97 Aldwick Road - March 2021.pdf

Drawing No.	Date:
D.1091 - 06	04-03-21
Rev.	Date:
A	27-03-21

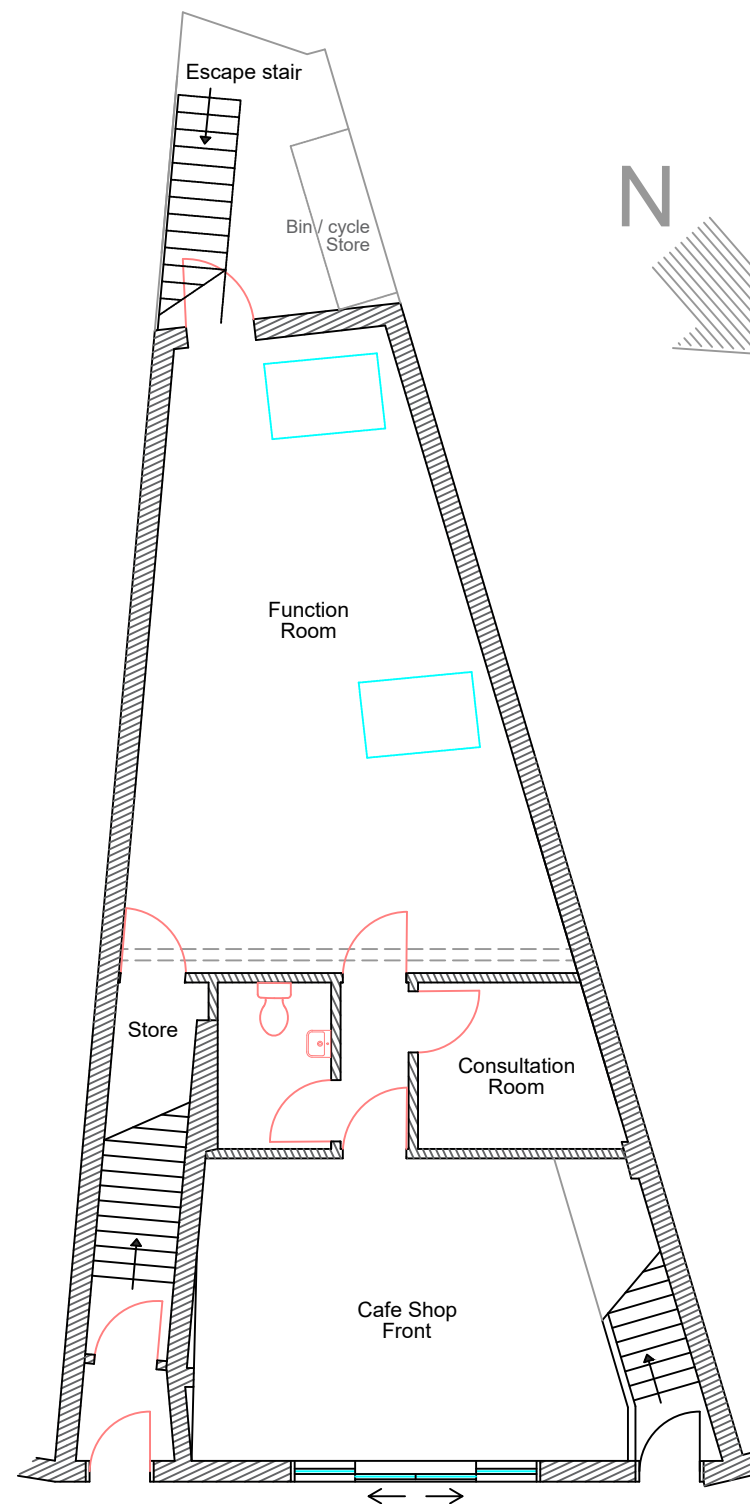
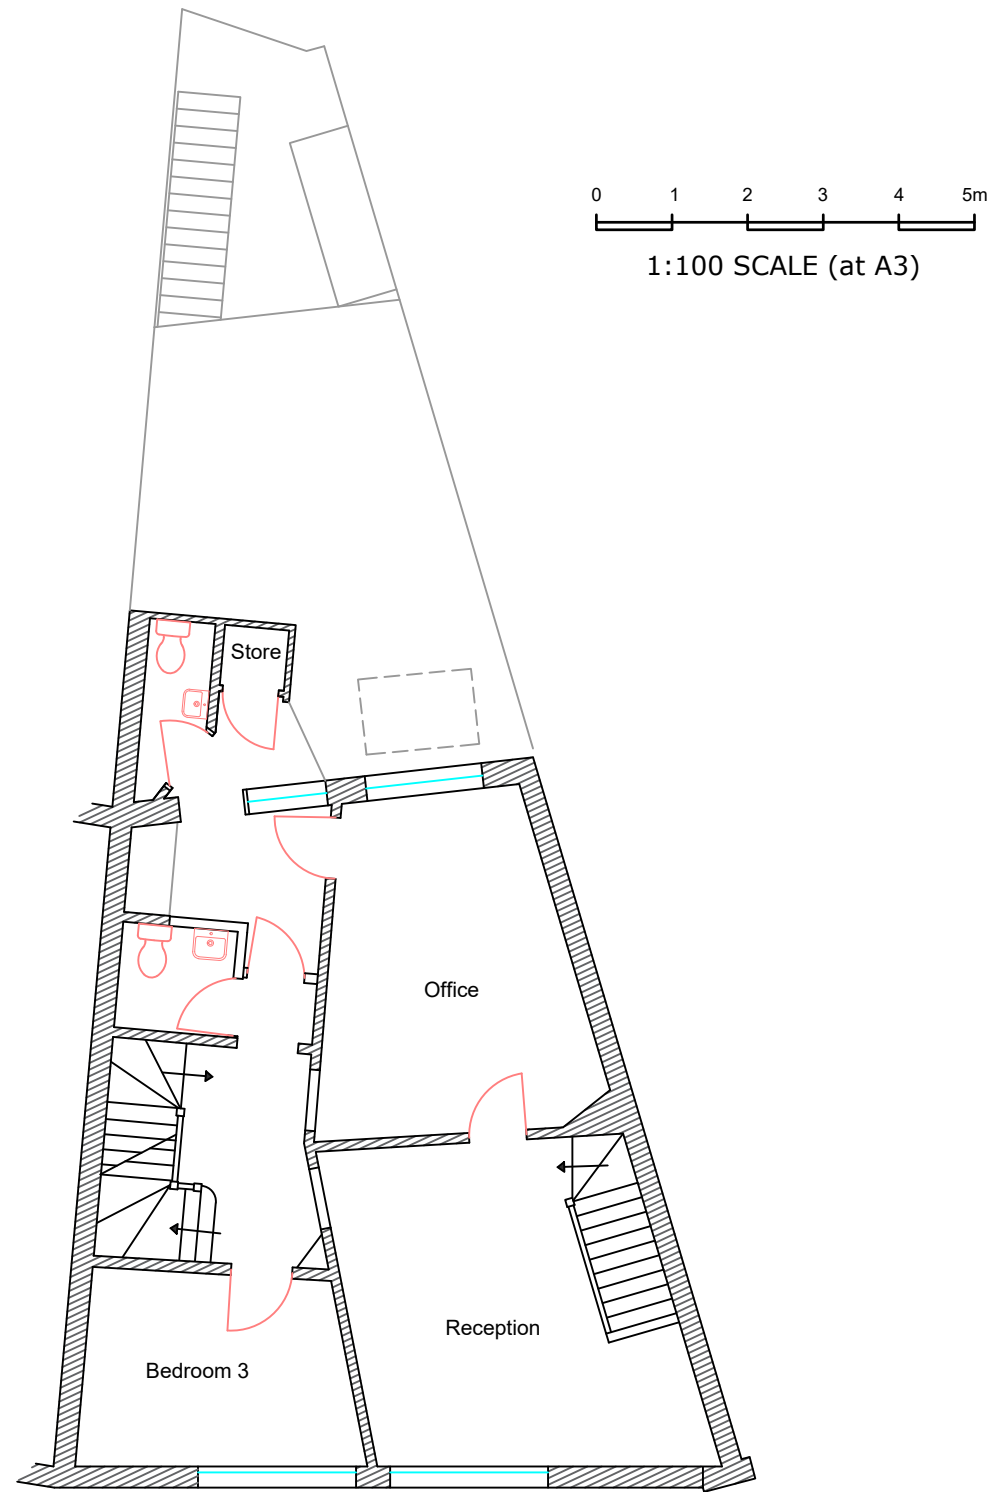
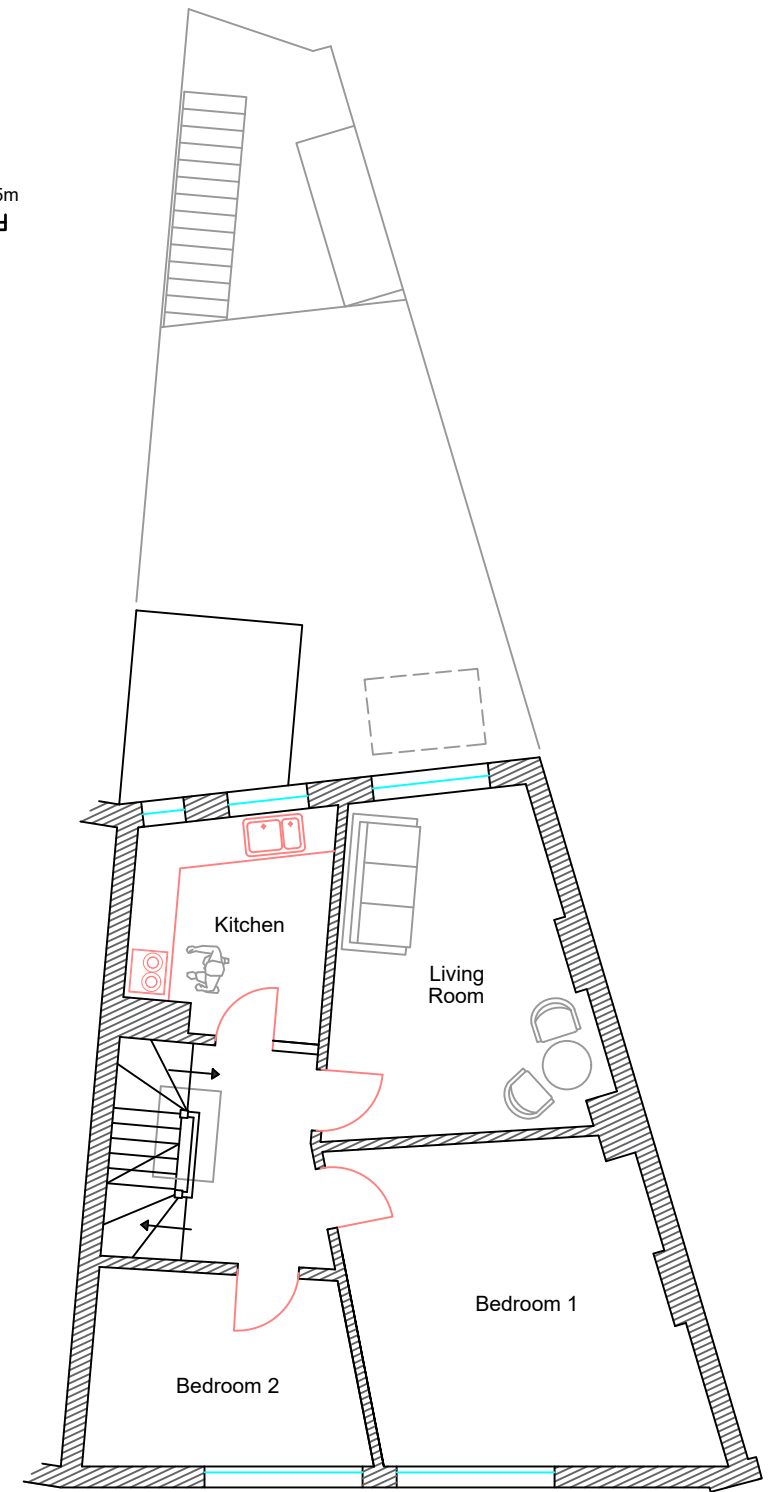
The proposed floor plans show 2 x Bedroom 2, please amend accordingly and re submit CIL Additional Information Form

My apologies, Please find attached a revised drawing which shows Bedroom 3 not Bedroom 2. The proposed development does not increase the number of bedrooms compared to existing and the residential floor area is also the same (slightly less). Please see attached the CIL Form as requested.
